Consultation Response from: KC Environmental Health (Pollution & Noise Control)
2025/92888 - 71B-71C, Huddersfield Road, Holmfirth
Installation of new shop front and X1 condenser unit (within a Conservation Area)
Date Responded:
Monday, 04 May 2026

Thank you for consulting Environmental Health on the above application.

GROUND FLOOR PLAN

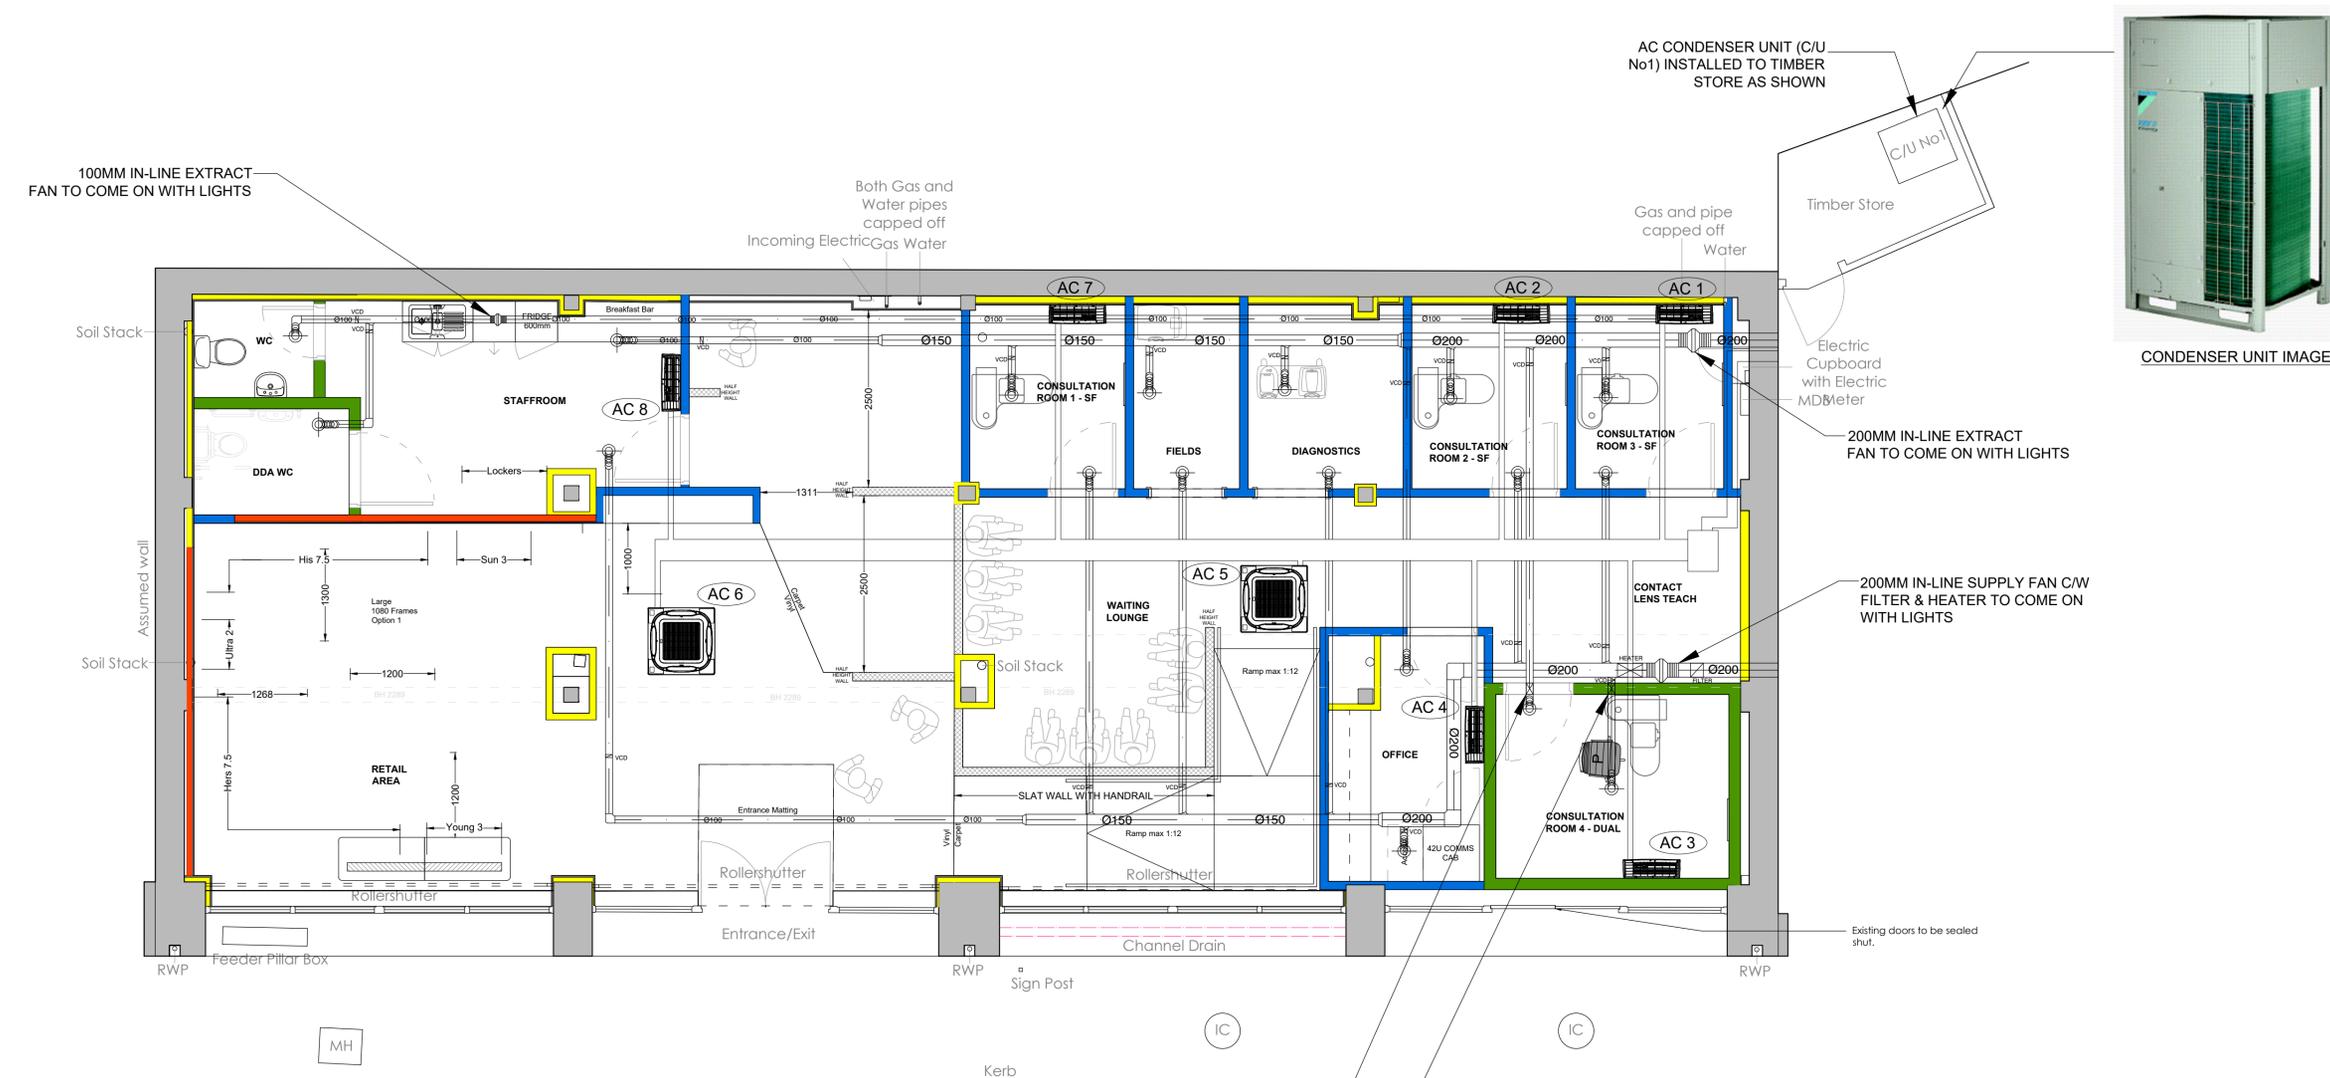
The submitted assessment has demonstrated that with the proposed noise mitigation measures, that noise levels from the proposed Daikin REYQ-8U (enclosed within the acoustic enclosure model DE-036, within the existing bin store) located to the side of the Specsavers store are satisfactory.

Environmental Health confirm we are satisfied that with the proposed noise mitigation measures, noise from the proposed Daikin REYQ-8U condenser unit will be acceptable.

NC14 Implement Agreed Noise Mitigation Measures – Condition

The development shall not be brought into use until all of the measures specified in the approved Noise Impact Assessment Report Ref: 11899/OP RevB, dated 15th April 2026, prepared by Acoustic Consultants Limited have been carried out in full and such measures shall be thereafter retained.

Figure 3: Proposed Plant Layout

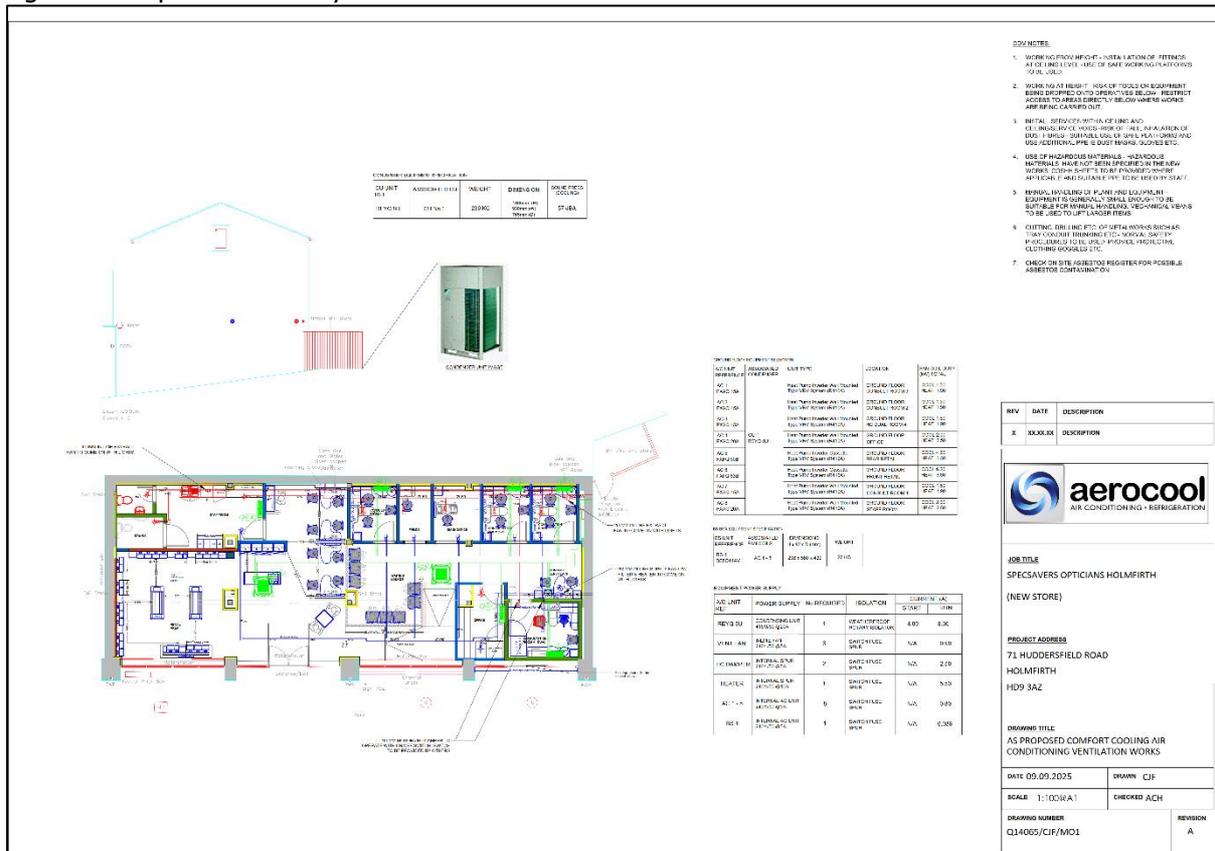
"There is 1no. condenser unit proposed; this unit shall be located within an existing timber bin store in an acoustic enclosure on the side elevation of the store at ground floor level."
